Project #: 1002062 Application #: 12DRB-70140

**City of Albuquerque  
Planning Department  
Inter-Office Memorandum**

SUBJECT: Project # 1002062

DEVELOPMENT REVIEW BOARD – SPEED MEMO

A1 SITE DEVELOPMENT PLAN FOR BUILDING PERMIT
 SCALE: 1" = 40'

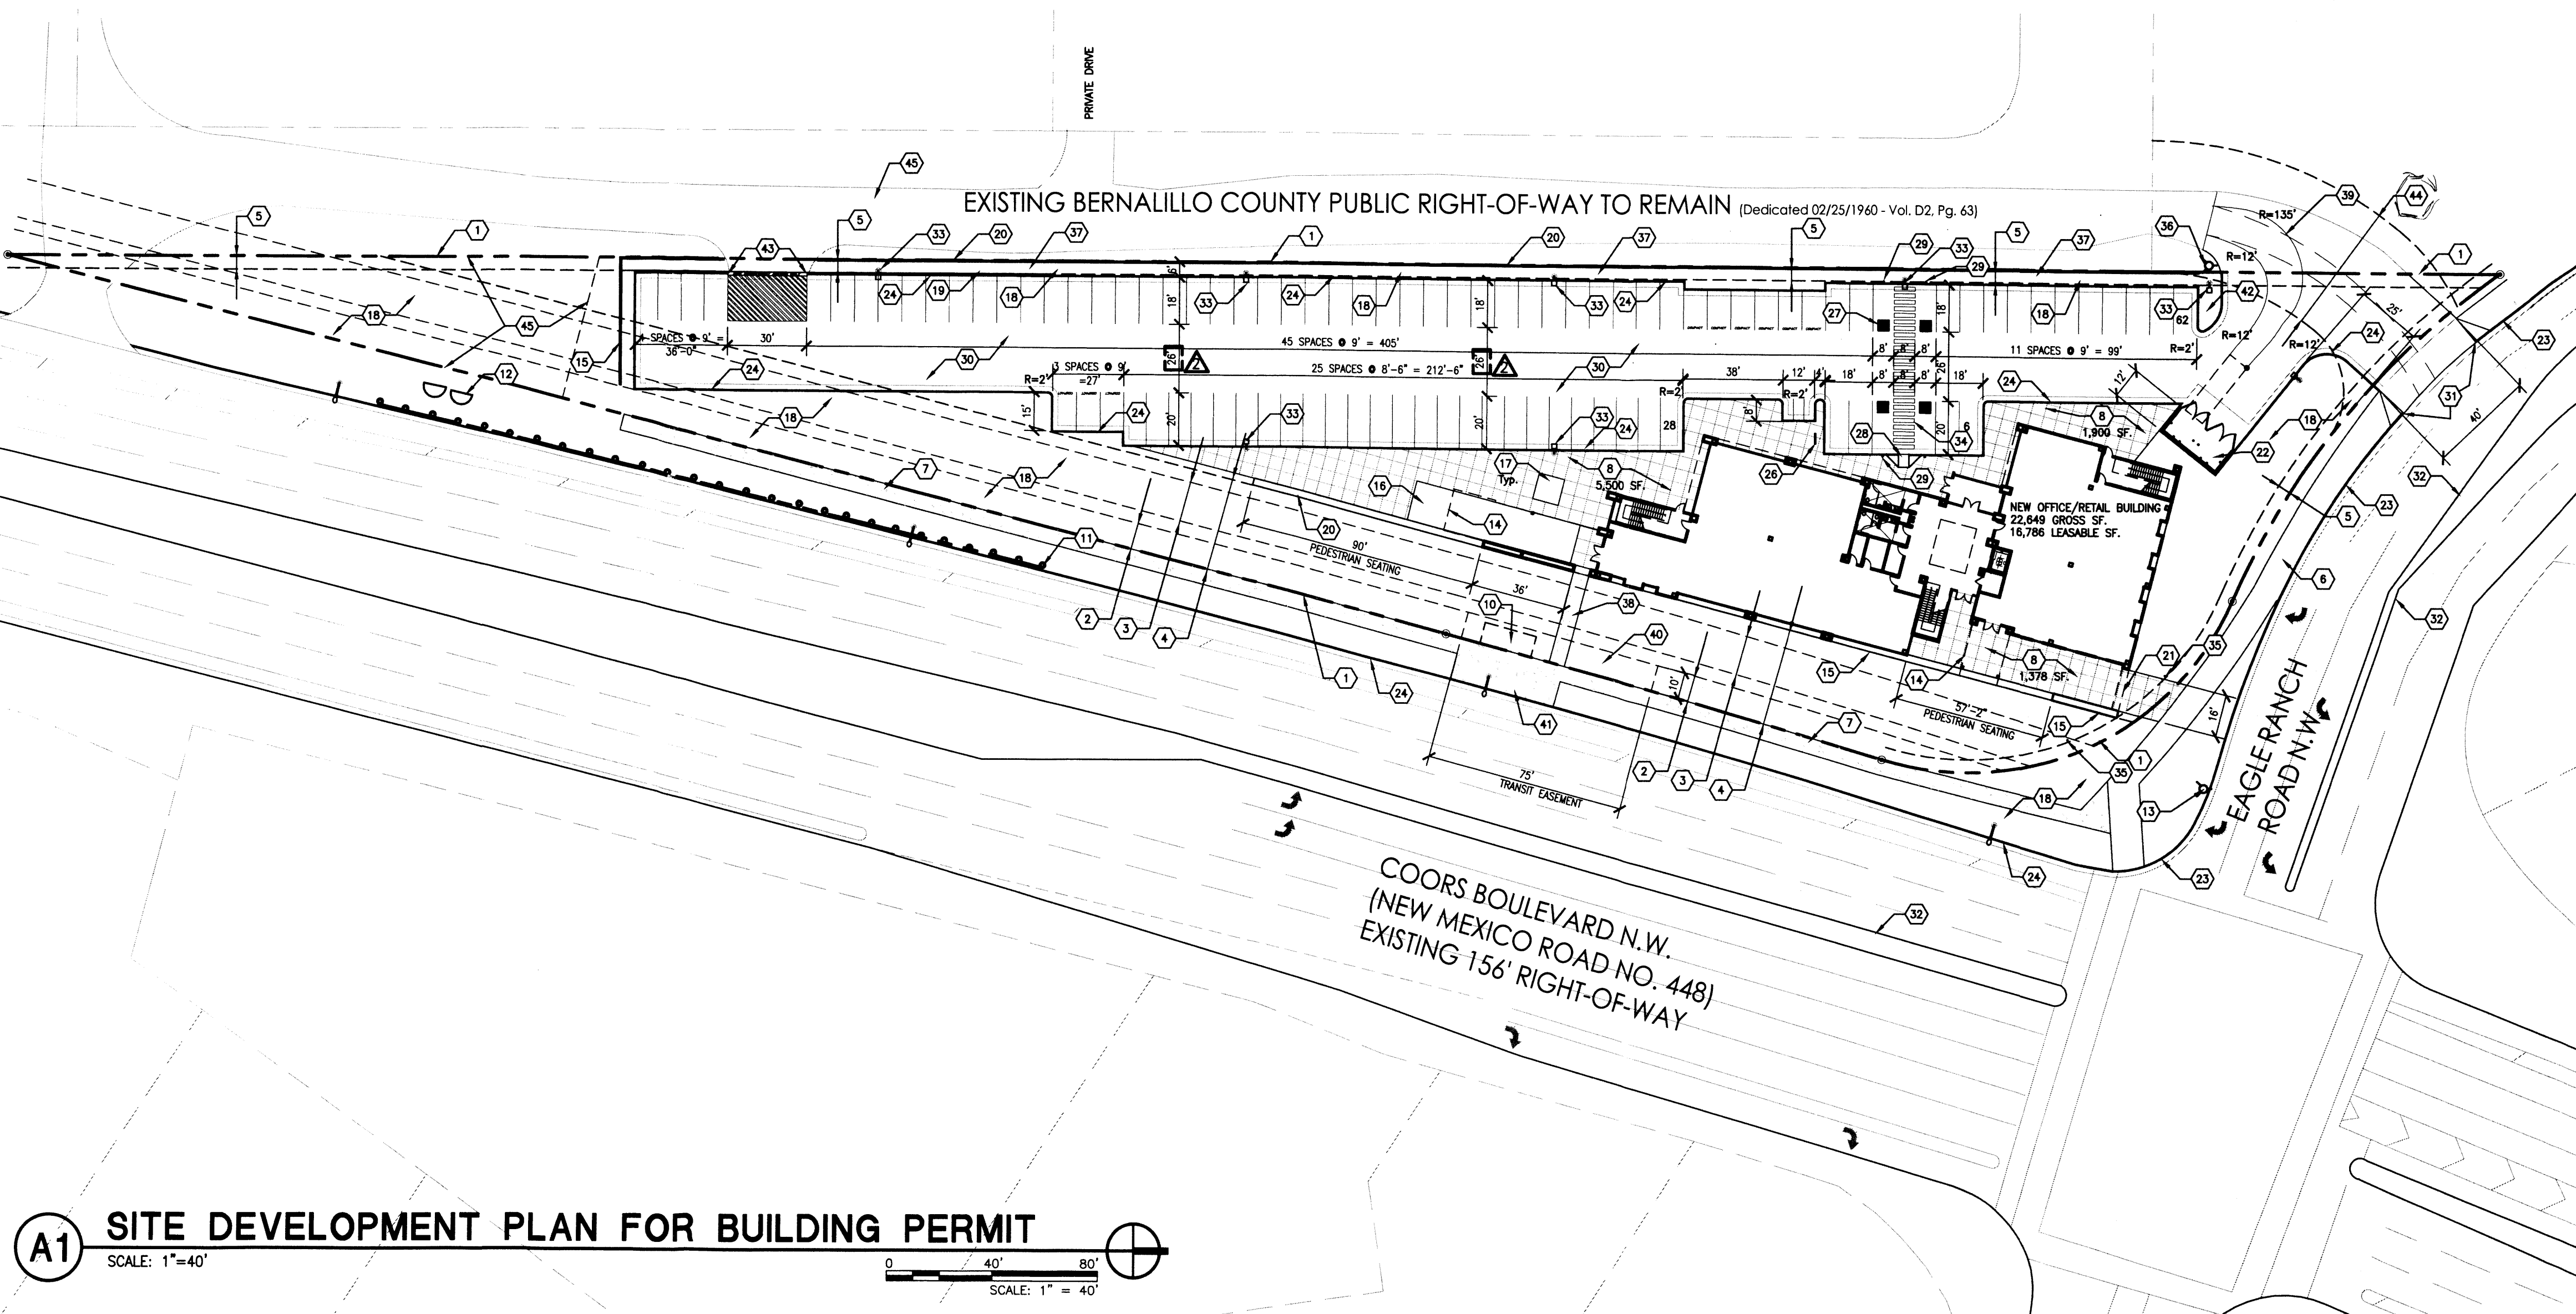
1. The landscaping plan is not consistent with the plaza paving shown on Sheet 1 (in response to Condition 5.d).
2. The street tree locations are inconsistent with the Street Tree Ordinance: "Street trees shall be placed between the curb and the public sidewalk and in the parkway, unless traffic safety requires different locations of trees." It is not clear if the proposed location of the trees was determined through consultation with NMDOT or City Transportation Services (Condition 6.d).
3. There is a new driveway shown onto Calle Norteña, which appears to have been added to satisfy the Fire Department's requirements (Condition 12.c).
4. UD&D Staff cannot confirm that the draft transit easement (5.a); AMAFCA approval (7.a); the Archaeological clearance certificate (10); Fire Marshall approval (12.c); and the sight distance exhibit (12.d) have been submitted.

**SITE PLAN
FOR
BUILDING PERMIT**

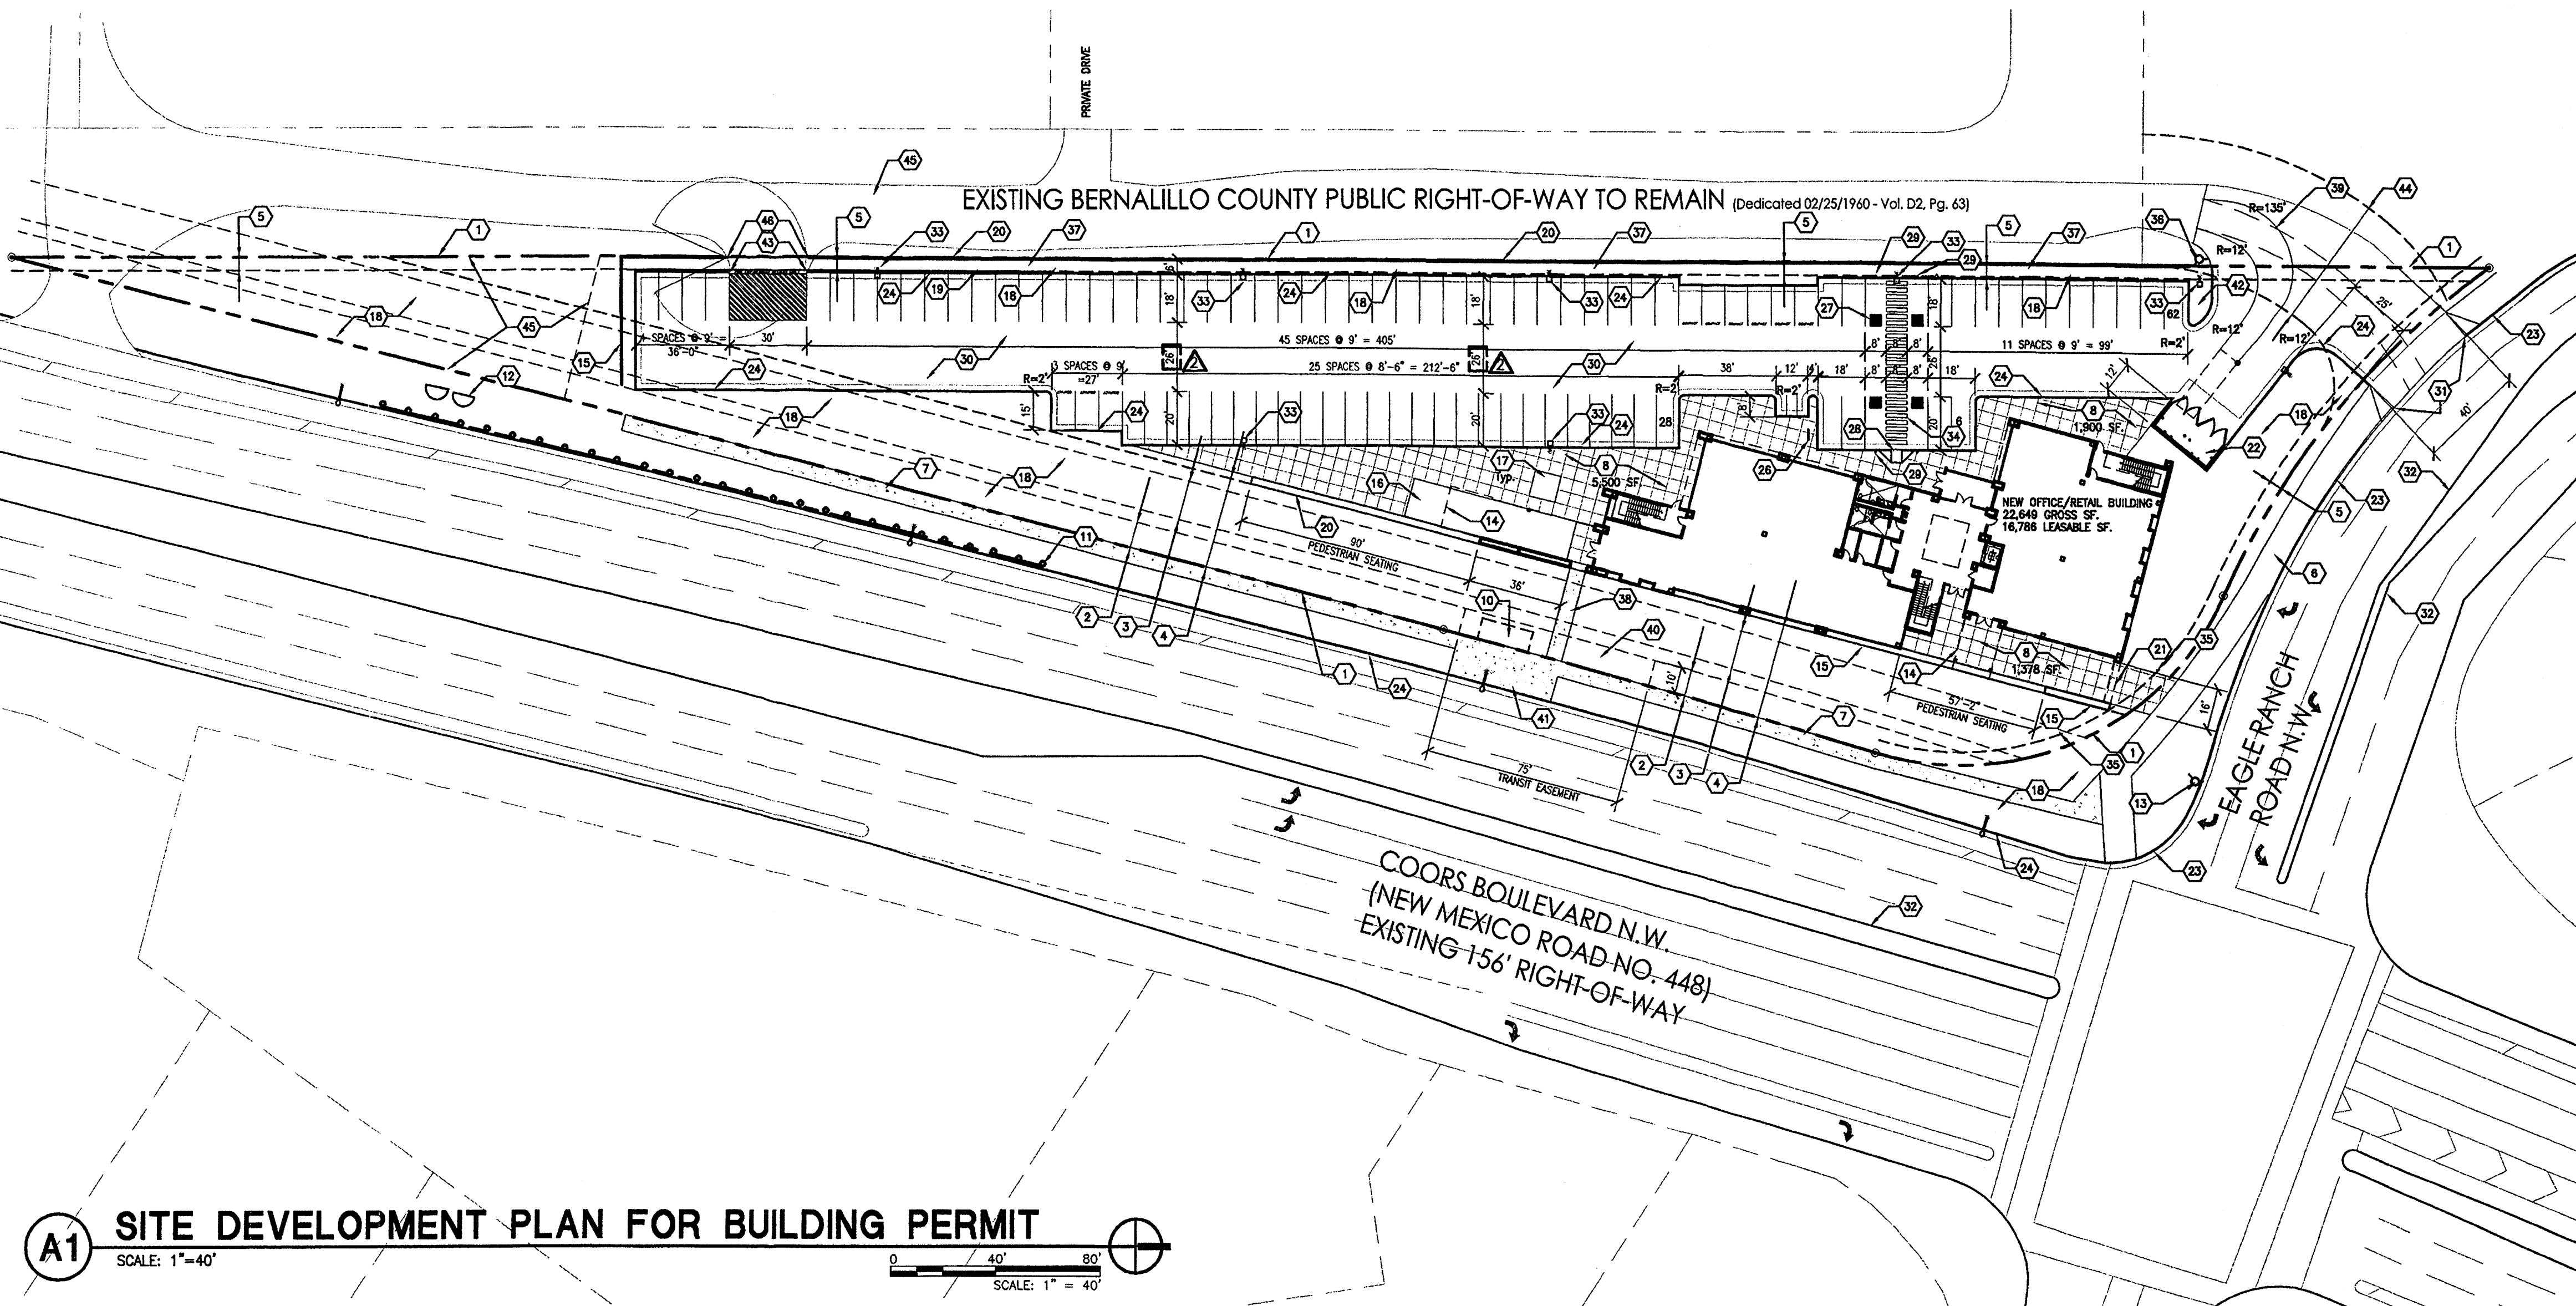
The NMDOT does not support the sidewalk waiver request; sidewalk must be shown along the entire frontage.

Per the Department of Municipal Development, 500 feet of clear sight from driver's eye to approaching traffic (3 to 8 feet above the gutter flow line) must be provided on Eagle Ranch Road.

Written permission from the County must be provided for the emergency access off of Calle Nortena.

- A DMS is located along this frontage; the proposed sidewalk may have to be relocated in this area.
- The existing guard rail may need to be adjusted when curb and gutter is installed.
- A full drainage review by the NMDOT is required prior to NMDOT sign off.
